An
Coimisiún
Pleanála

Technical Note: Ecology R323410TN

Proposed Limerick City Greenway (UL to NTP) within the townlands of Dromroe, Sreelane, Newcastle and Castletroy, Co. Limerick.

DAU submission, EIAR (Biodiversity) including lesser horseshoe bat, and NIS including Annex I habitat and Annex II species otter.

PROPOSED BRIDGE: SECTIONAL-ELEVATION A1 (scale 1:25)

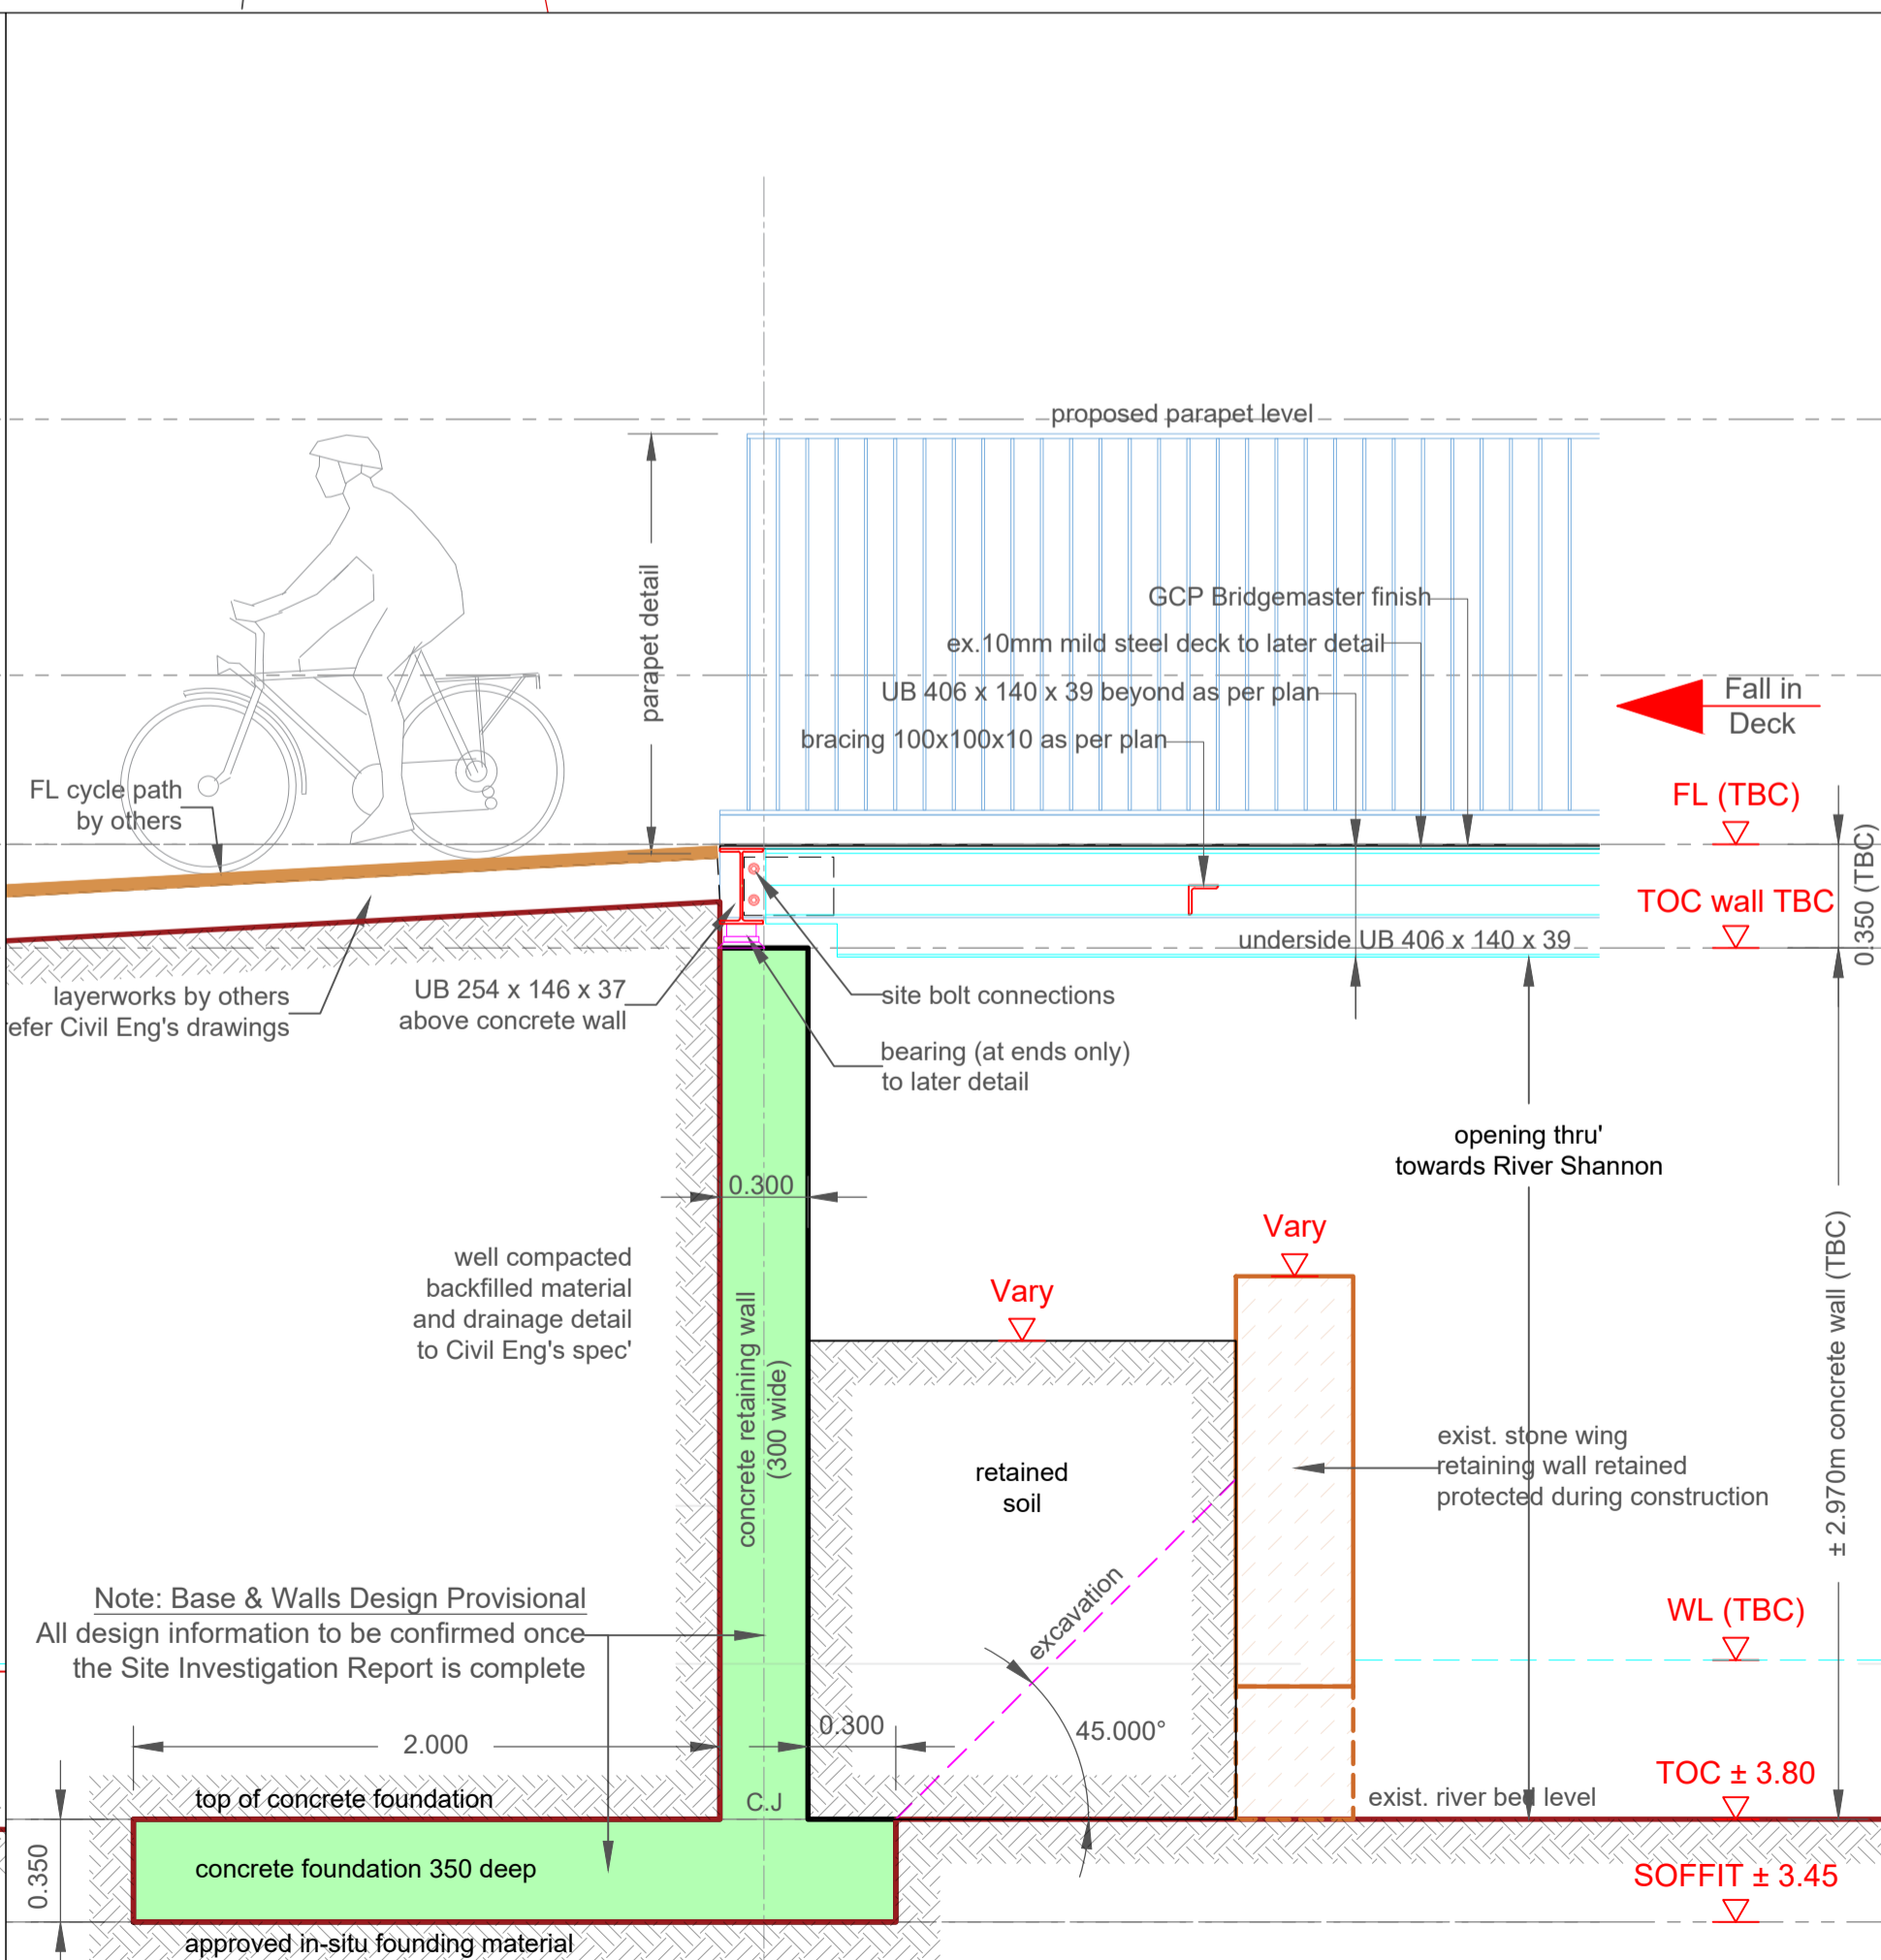
- 3.1.9. It is argued in the application documentation, particularly with respect of the proposed Bridge no.2 at Ch0+970, that alluvial woodland communities recorded here no longer support the structure and function attributes of Annex I habitat 91E0 Alluvial Woodland. While the Structure and Functions of the 91E0 habitat may be in ‘Unfavourable’ condition at this site (e.g. due to a low number of indicator species, cover of non-native invasive species, lack of regeneration etc.), the habitat is still assigned Annex I status⁶. It is also noted in the CO document that there is an absence of suitable terrain to accommodate the expansion of alluvial woodland, therefore the priority for the SAC is to protect and restore existing woodland. The construction of a bridge at this location would effectively impede future restoration of the 91E0 habitat in this area and failure to achieve conservation goals.
